**WEST SUSSEX COUNTY COUNCIL  
INFRASTRUCTURE CONSULTATION**

**SUBJECT: WA/36/10**

**Ashurst, Binsted Lane, Binsted**

**Retrospective application for the retention of boundary fence and proposed replacement of main gate**

ASHURST
BINSTED LANE
BINSTED BN18 0LPtitle PLANNING APP FOR WALLS /
FENCE ON BINSTED LANE

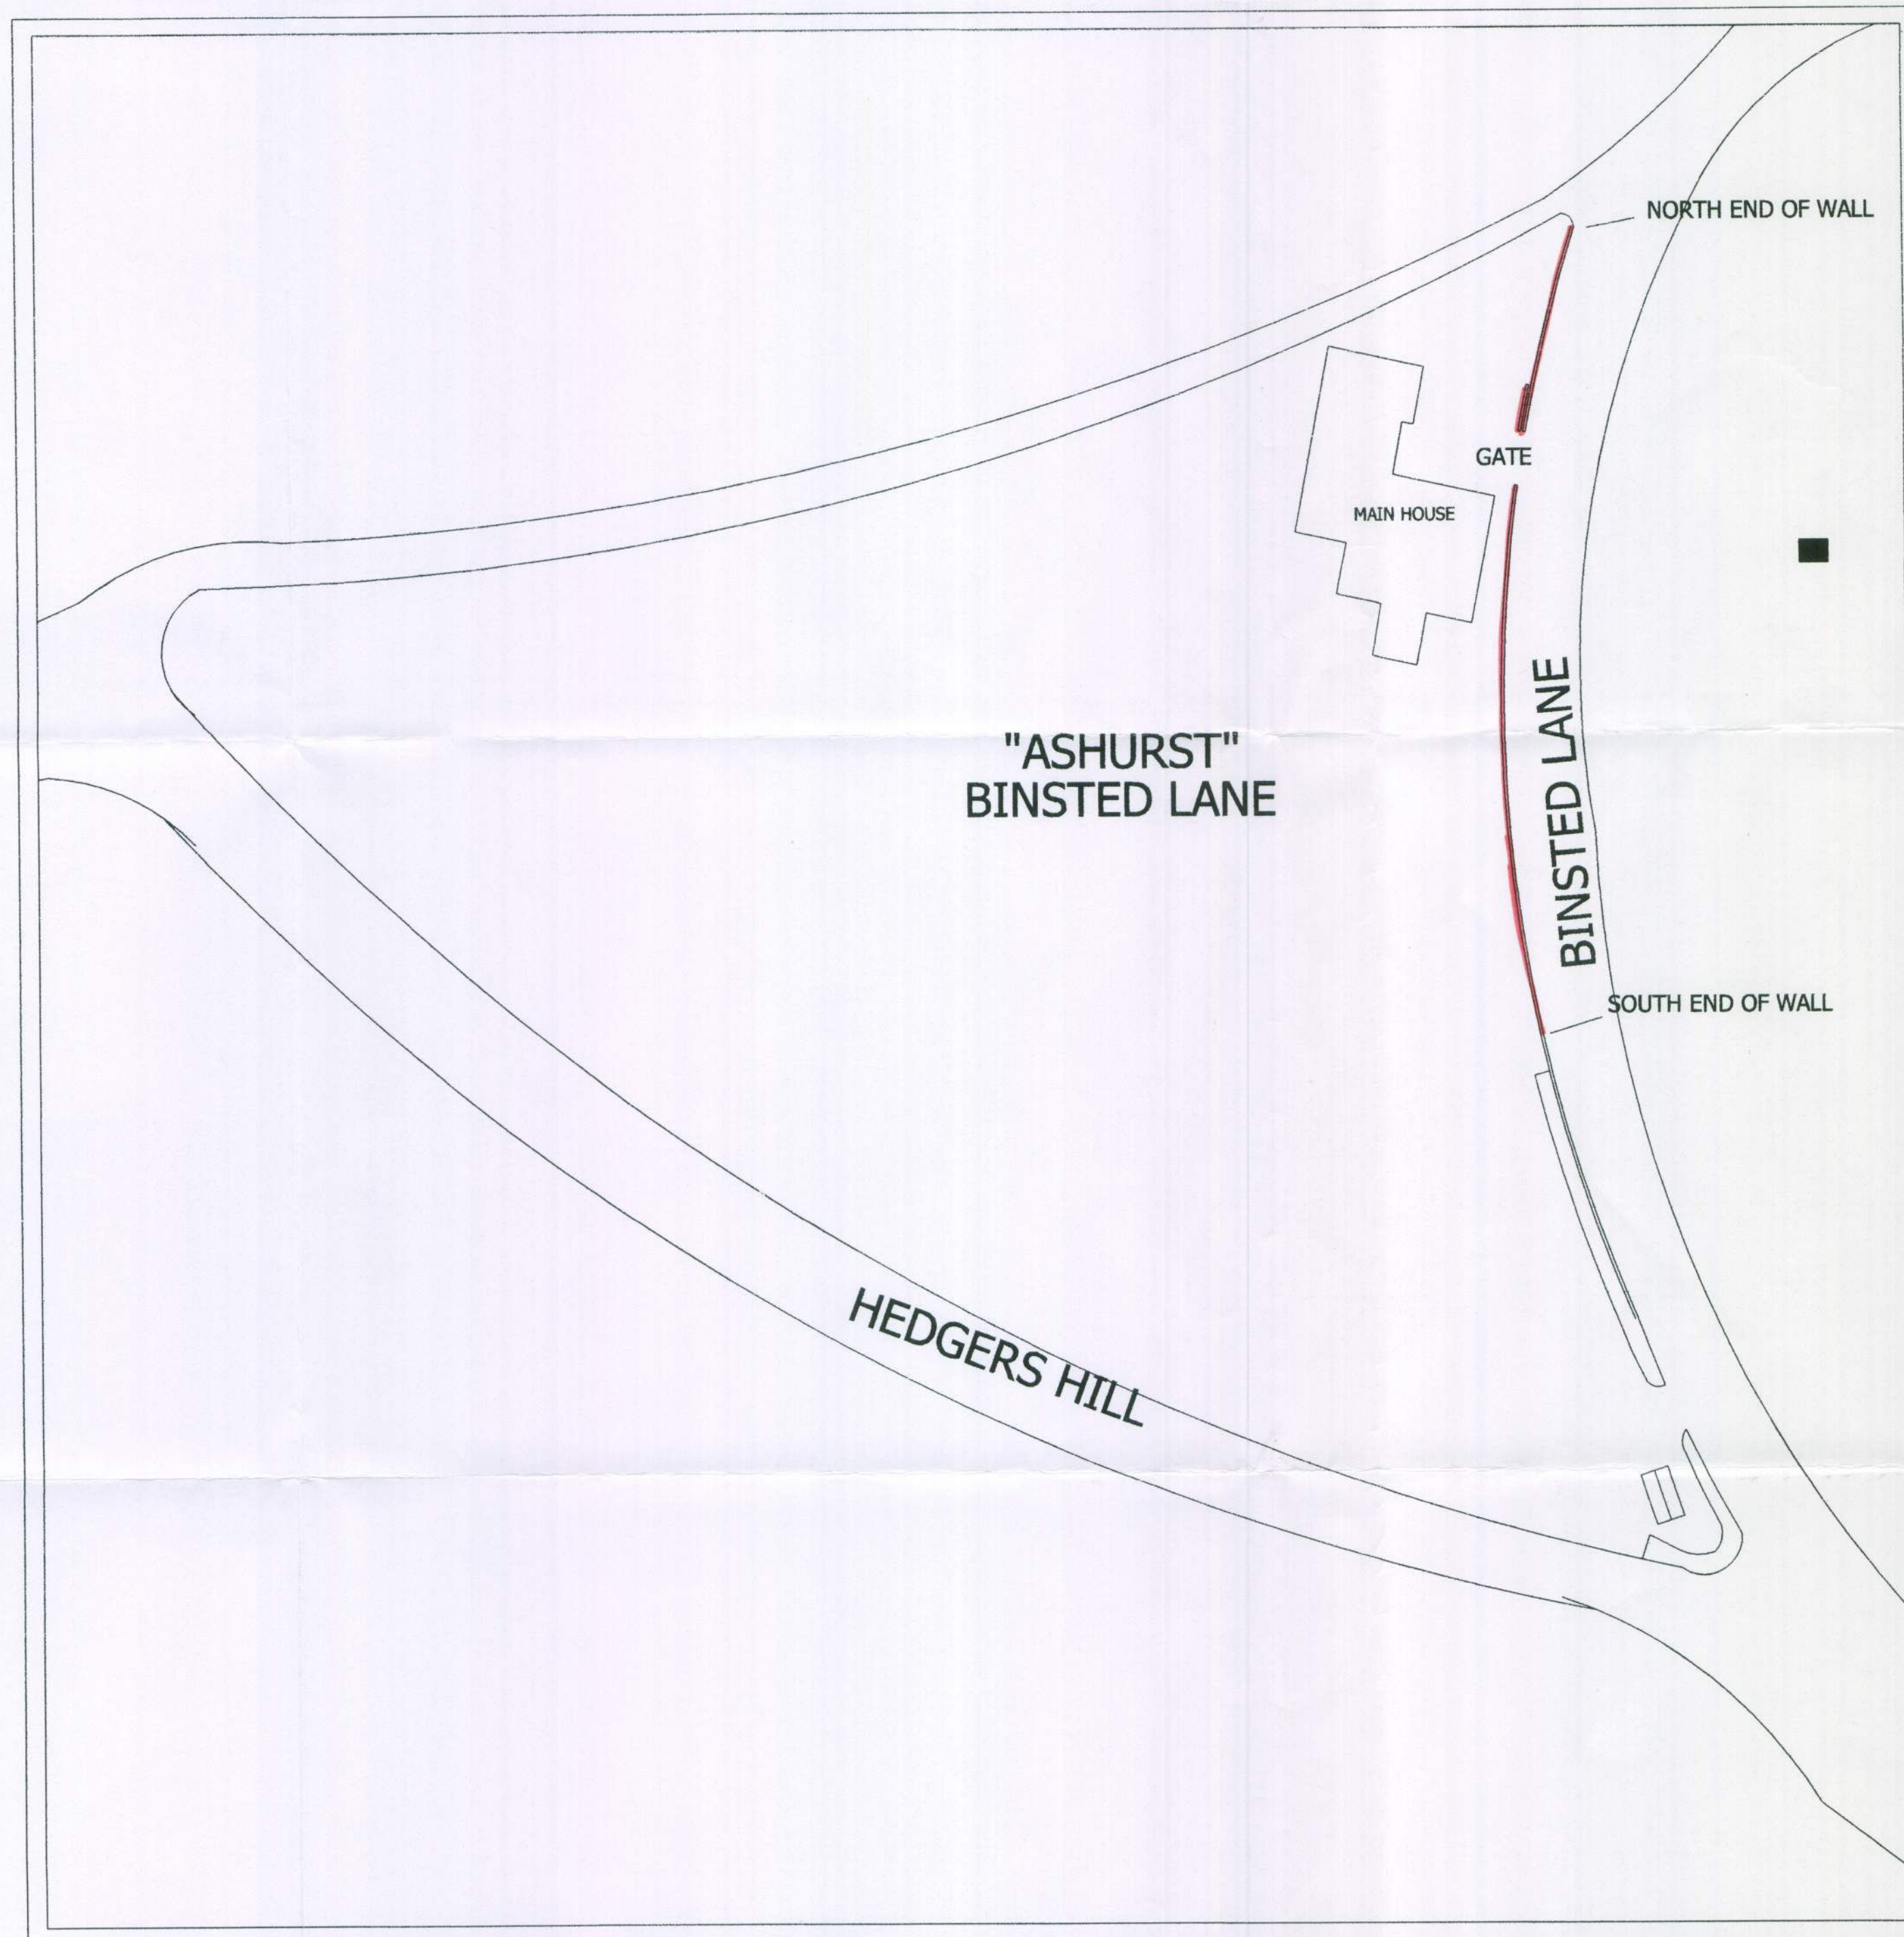
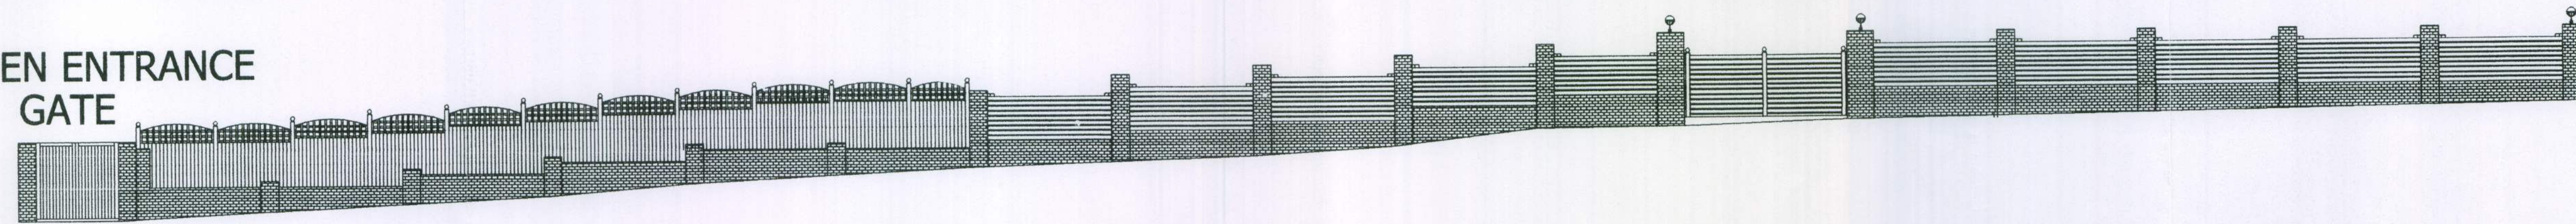
From an inspection of the plans alone, the fence does not appear to be located within the publicly maintainable highway, nor does it affect the legal line of Footpath 337 adjacent to this site. Furthermore, visibility is not compromised by the retention of this fence.

The application also concerns the 'replacement of the main gate', which would suggest that a gate has existed in this location for a period of time already, and the most recently available verified accident records reveal there have been no personal injury accidents in the vicinity of the existing point of access. WSCC would prefer any gates at the site to be located 5m back from the edge of the carriageway of Binsted Lane.
